JPW-SK-0000
 AREA OPTION 10
 UPPER LEVEL PLAN
 23-01-2017

DW MARKUPS FOR IMPROVEMENTS 9.6m GRID.

DESIGN EXCELLENCE REPORT
Chau Chak Wing Museum

Drawing Title
**ELEVATION
WEST**

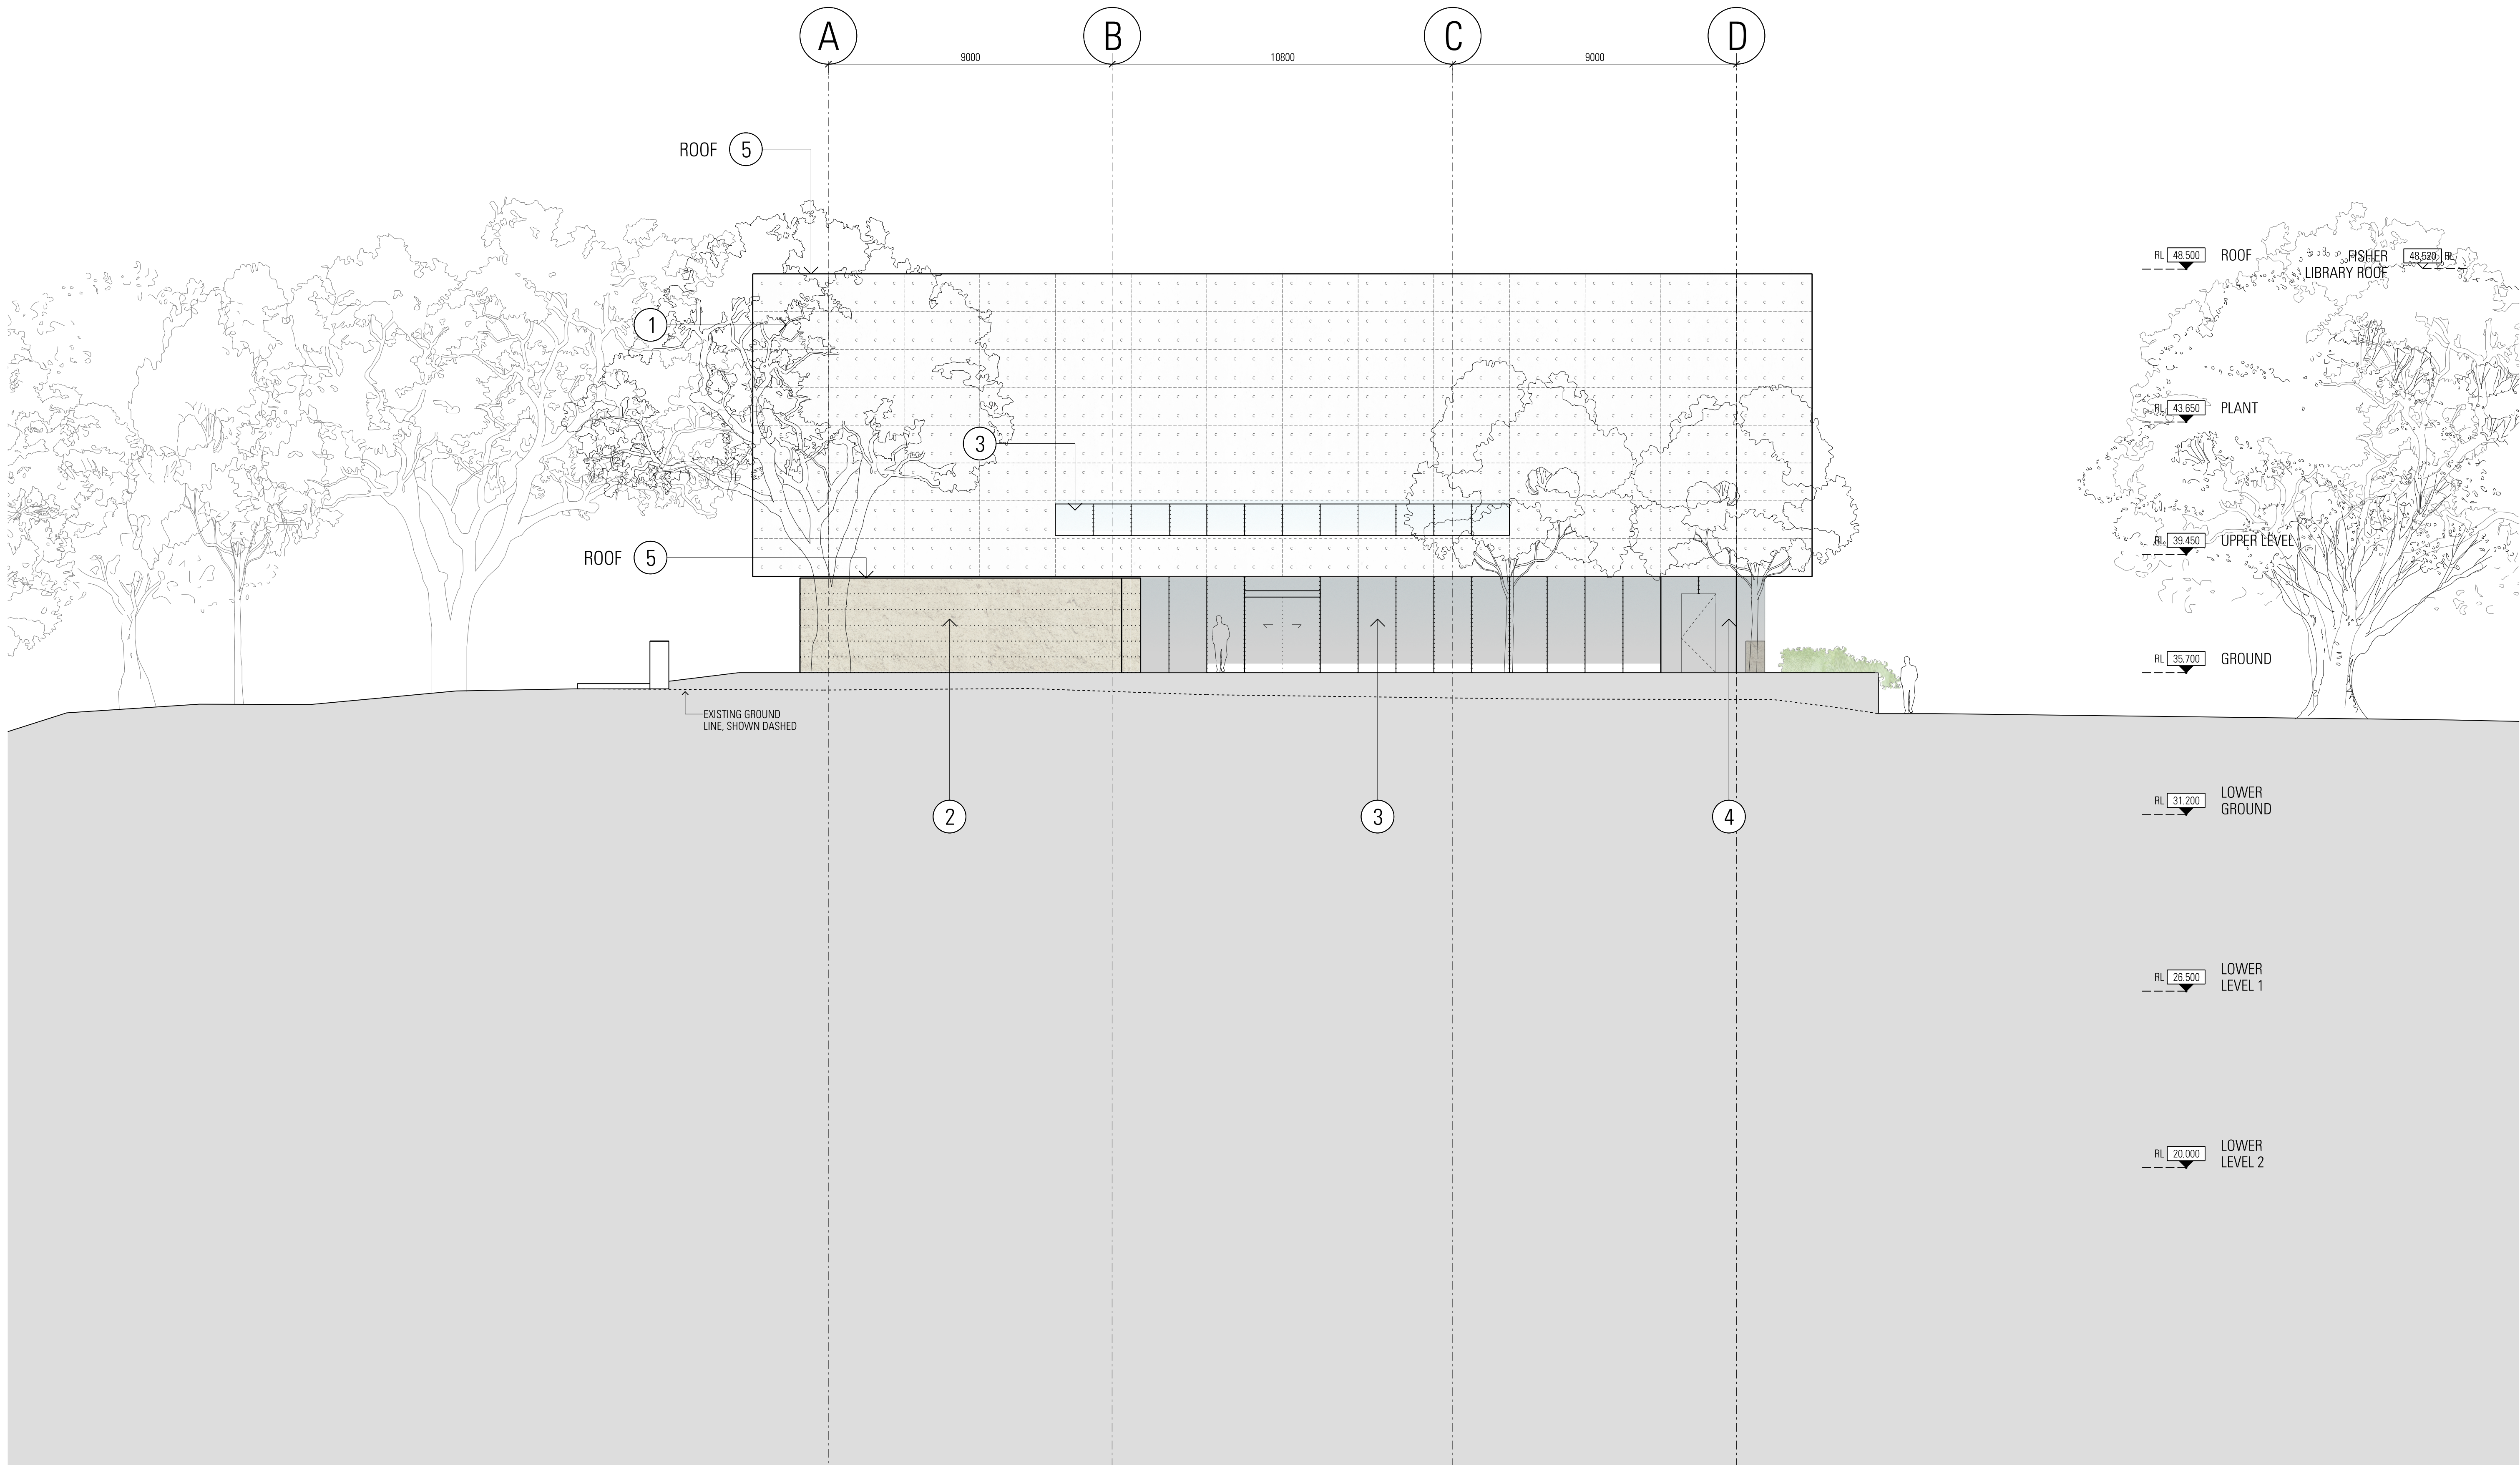
THIS ELEVATION WILL NOT BE
 PART OF PRESENTATION MATERIAL
 (PROBABLY!) BUT FINISHES WILL
 NEED TO BE SET OUT FOR
 PLAN & 3D MODEL (ROUNDES).

ELEVATION SHOULD BE CHANGED TO
 CUT THROUGH SOURCE INFESTED
 OF MUSEUM.
